BURPHAM PARISH MEETING

Ref: B/26/11 The Stables, Burpham

South West Elevation - Proposed

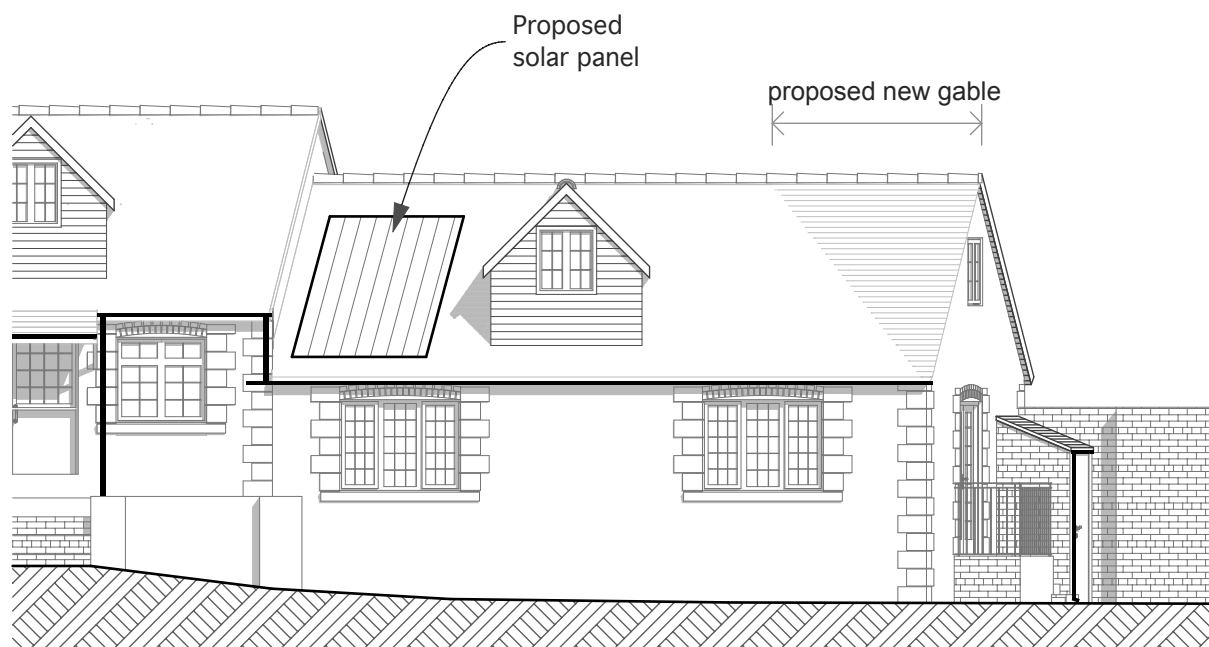
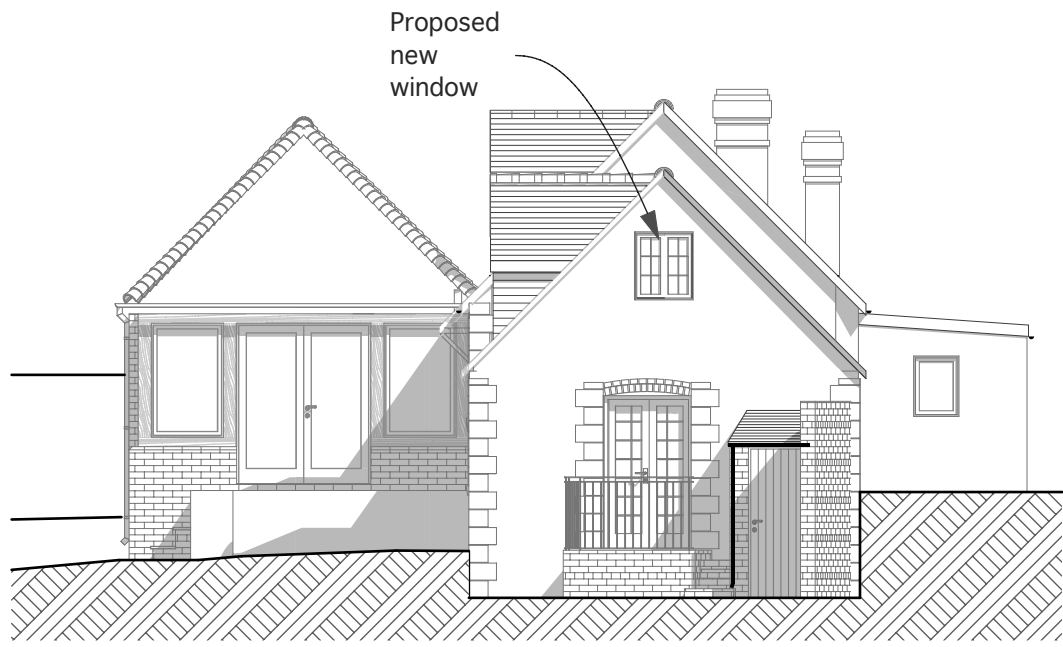
The Campbell's already have planning permission to extend and modernise their cottage. The change to the gable end will improve the new upstairs accommodation. The new window does not overlook neighbour's property.
